Chase Bank 11004 Montgomery Blvd NE Traffic Circulation Layout

Engineer's Stamp 05-19-2021 (G12-D018A)

Chase bank is only a lease of 0.356 acres area for the proposed new bank and does not have authorization to make site improvements or changes to the 2.795-acre TR B-1-B TARA SUBD REPLAT OF TR B-1. The existing development has 11 tenants.

C1.01

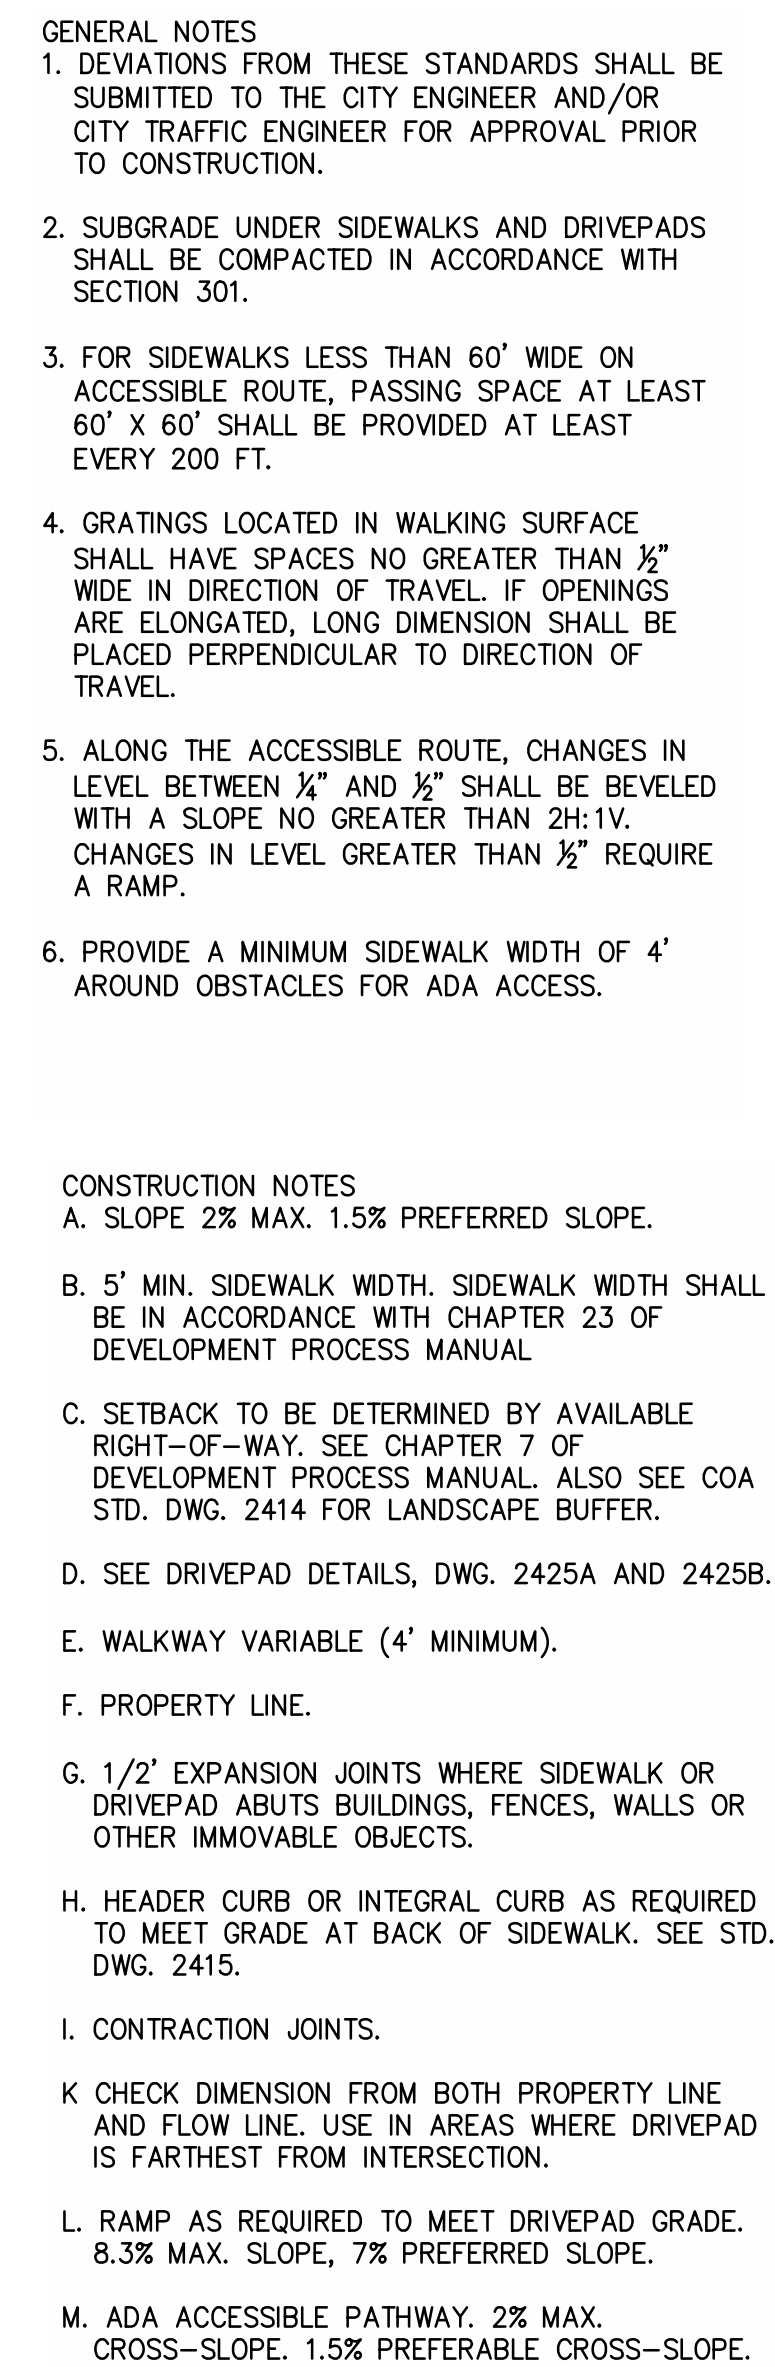
1. Please show a vicinity map showing the location of the development in relation to streets and well-known landmarks.

4. Identify all existing access easements and rights of way width dimensions (if applicable).

5. Maximum access width for arterial, collector, and local streets are as follows:

16. Show all drive aisle widths and radii. Some dimensions are not shown.

17. The minimum drive aisle dimensions are shown below

18. List radii for all curves shown; for passenger vehicles. Radius for delivery trucks, fire trucks, etc. is 25ft. or larger.

19. Per the IDO, a 6ft. wide ADA accessible pedestrian pathway is required from the public sidewalk to the building entrances. Please clearly show this pathway and provide details.

20. Per DPM, a 6 ft. wide ADA accessible pedestrian pathway is required from the ADA parking stall access aisles to the building entrances. Please clearly show this pathway and provide details.

22. It is not apparent what type of pavement surface is being proposed. A hard driving surface will be required as part of this proposed project for parking area and drive aisles. Provide surface design for parking lot.

23. Provide existing sidewalk widths on public street frontage.

24. Clear sight distance exhibit doesn't function since its location/placement is on the ingress lane. Instead provide a stopping sight distance exhibit on the egress lane.

Response: Vicinity Map added.

Response: Easements has been provided.

Response: Access width dimensions added to the plans.

Response: Dimensions added.

Response: Dimensions added.

Response: Dimensions added.

Response: 6 ft wide ADA Path added.

Response: 6-ft ADA pathway added.

Response: Pavement will match existing asphalt pavement. Note added to plans.

Response: Dimensions added.

Response: Clear Sight Triangle relocated to the egress lane.

MOTORCYCLE
PARKING SIGN
N.T.S.

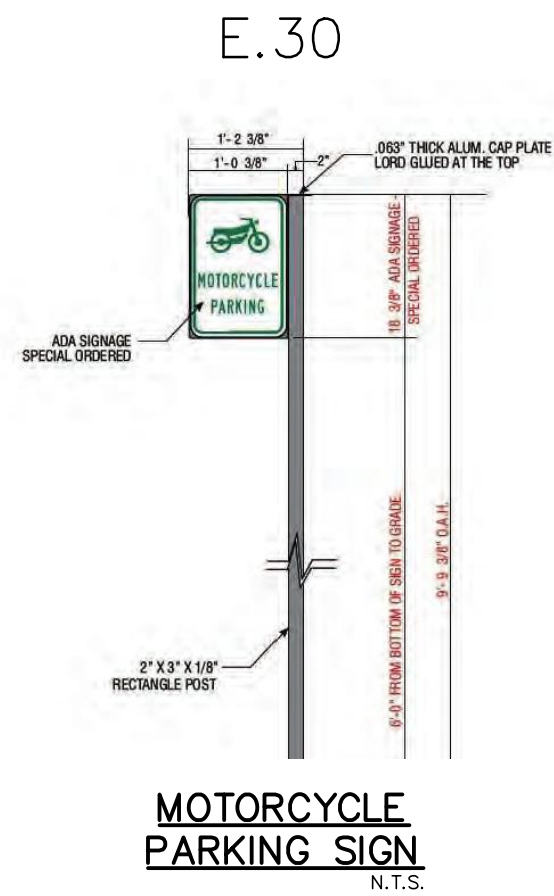
11. Motorcycle parking spaces shall be designated by its own conspicuously posted upright sign, either free-standing or wall mounted per the zoning code. Provide sign face detail for proposed sign.

Response: Motorcycle parking signage added.

ADA SIGNAGE FOR VAN
ACCESSIBLE SPACES
N.T.S.

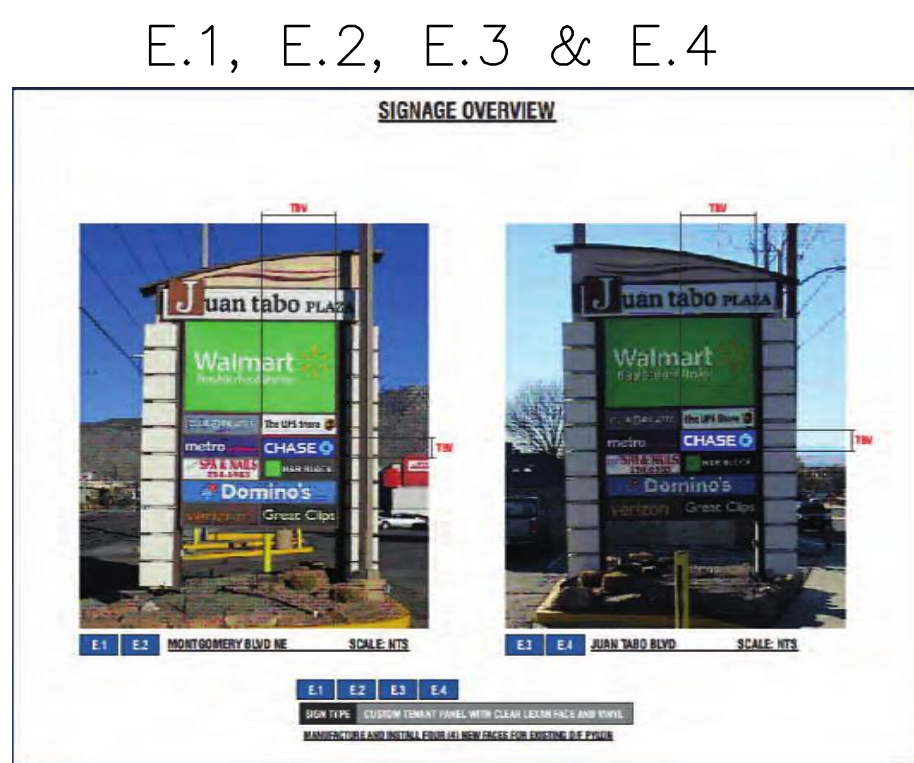
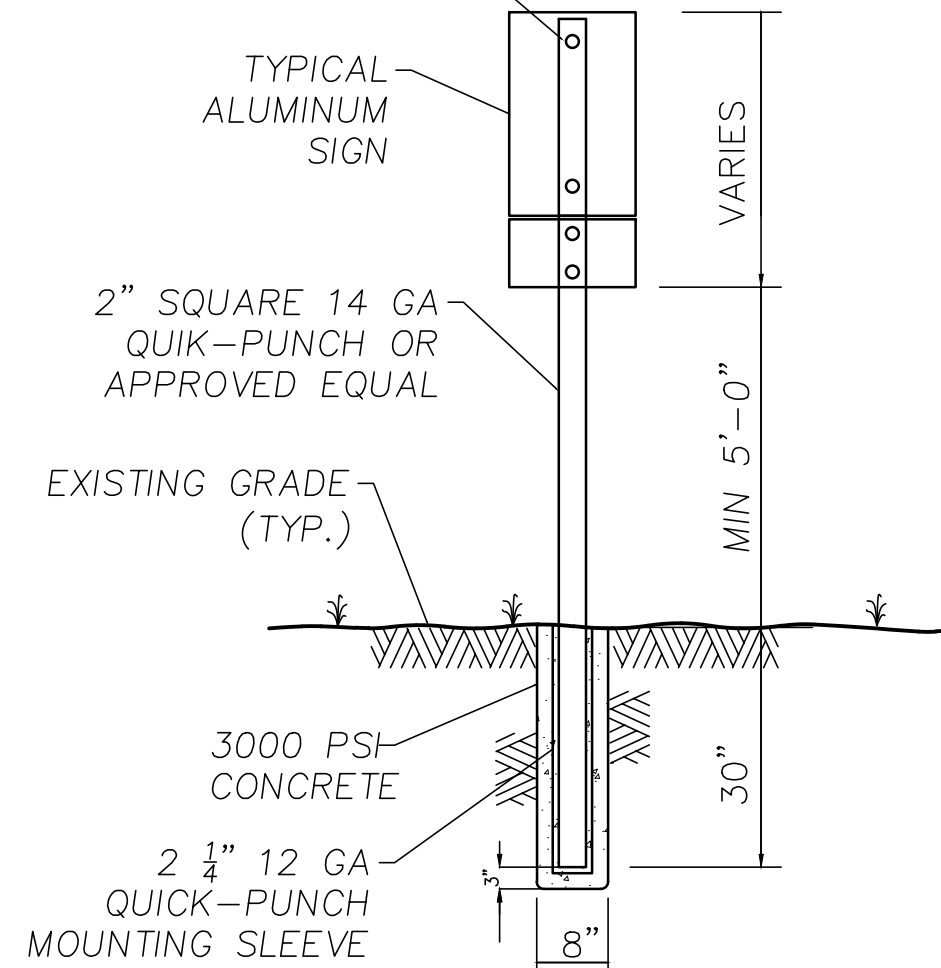
8. The ADA accessible parking sign must have the required language per 66-7-352.4C NMSA 1978 "Violators Are Subject to a Fine and/or Towing." Please call out detail and location of signs.

Response: Required language added to parking ADA accessible parking sign.

ADA RAMP DETAIL
N.T.S.

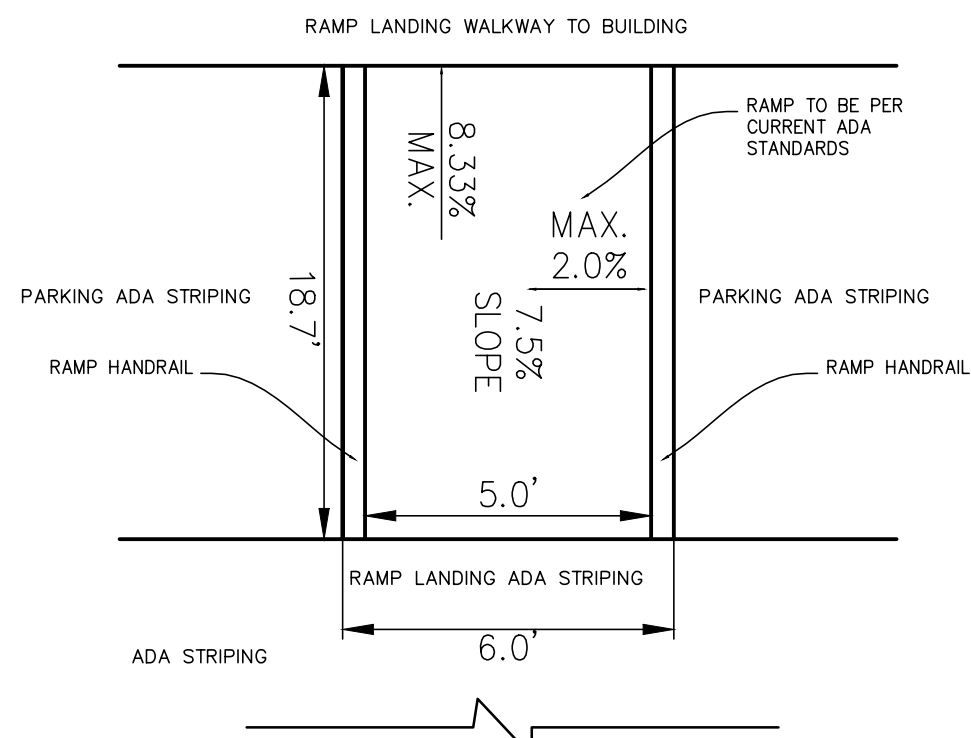
9. ADA curb ramps must be updated to current standards and have truncated domes installed (Montgomery Blvd frontage/entrance).

Response: Noted. Per discussion with the property owner representative, they have requested we restrict our work to the negotiated lease area.

HANDRAIL DETAIL
N.T.S.

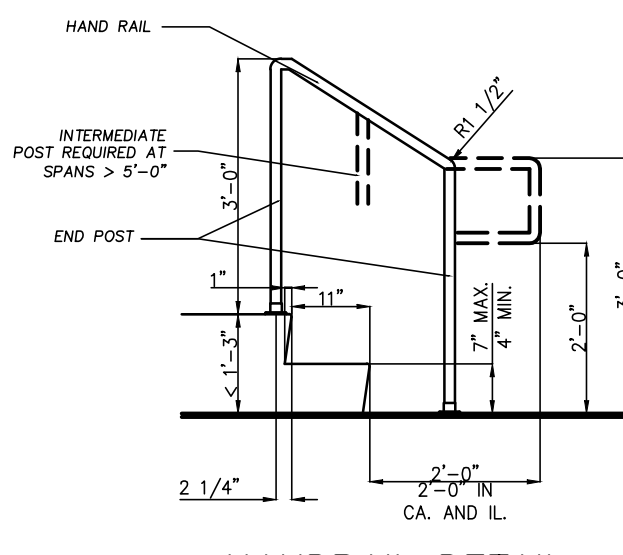
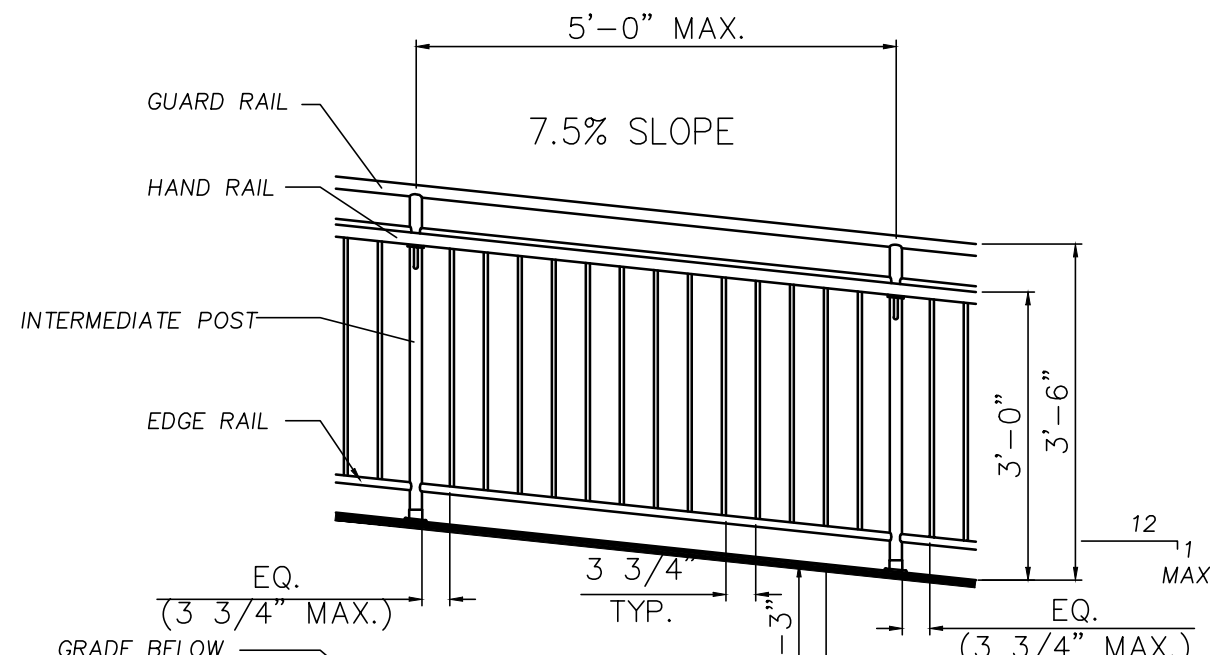
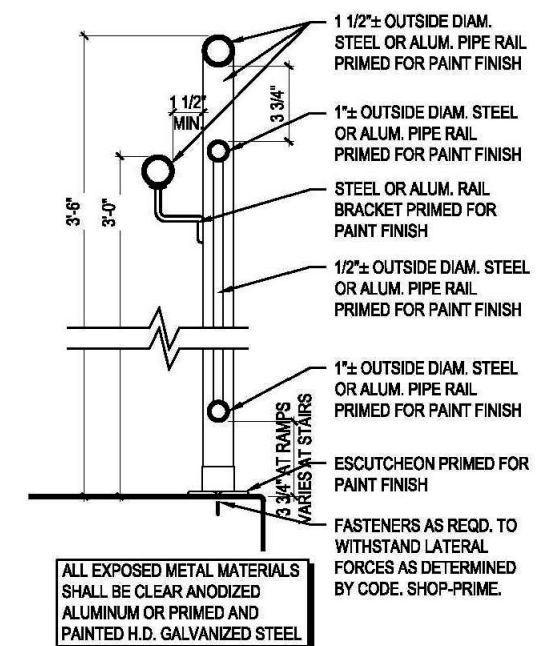
10. Please provide an overall details/full segment of proposed handrails (Needs to follow ADA Accessible Guidelines).

Response: Handrail detail provided.

BICYCLE RACK DETAIL
N.T.S.

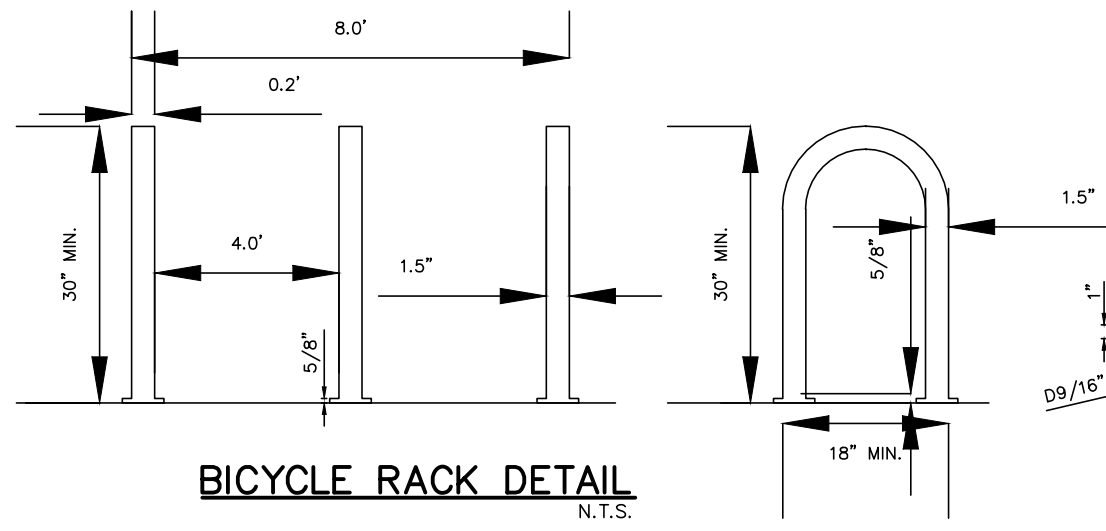
12. All bicycle racks shall be designed according to the following guidelines {IF APPLICABLE):

- a. The rack shall be a minimum 30 inches tall and 18 inches wide.
- b. The bicycle frame shall be supported horizontally at two or more places. Comb/toaster racks are not allowed.
- c. The rack shall be designed to support the bicycle in an upright position. See the IDO for additional information.
- d. The rack allows varying bicycle frame sizes and styles to be attached.
- e. The user is not required to lift the bicycle onto the bicycle rack.
- f. Each bicycle parking space is accessible without moving another bicycle.

13. Bicycle racks shall be sturdy and anchored to a concrete pad.

14. A 1-foot clear zone around the bicycle parking stall shall be provided.

15. Bicycle parking spaces shall be at least 6 feet long and 2 feet wide.

Response: Bicycle parking rack added. Reference sheet C1.03 for details.

Response: Bicycle concrete pad shown on plan.

Response: 1-foot clear zone shown on plan.

Response: Noted. Reference sheet C1.03 for dimension details.

ADA PARKING STALLS AND AISLE DETAIL
N.T.S.

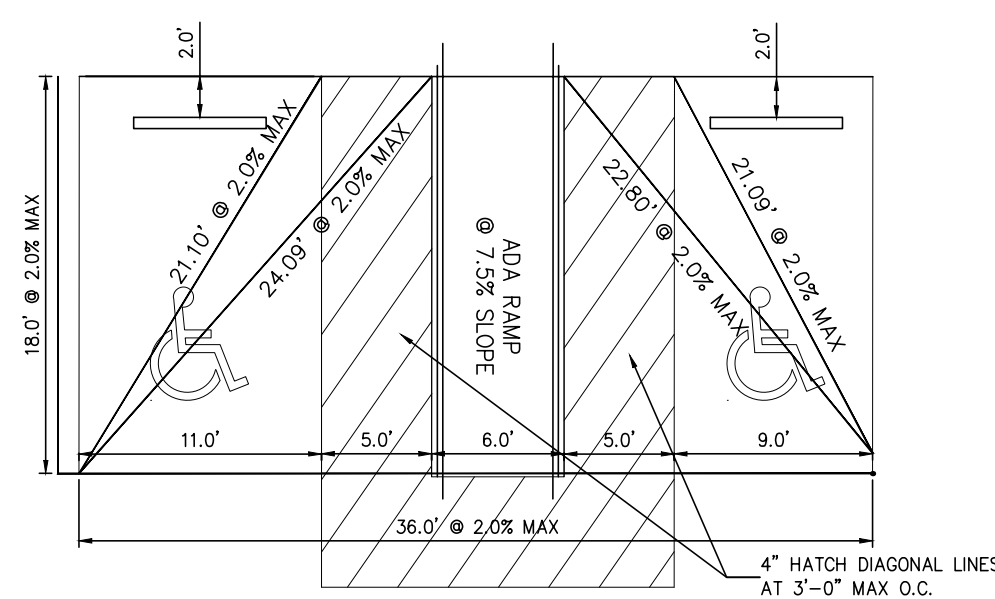
7. The ADA accessible spaces must include an access aisle. Van accessible aisles should be 8ft wide; all others should be 5ft wide.

Response: ADA van accessible aisle width updated to reflect 8-ft width.
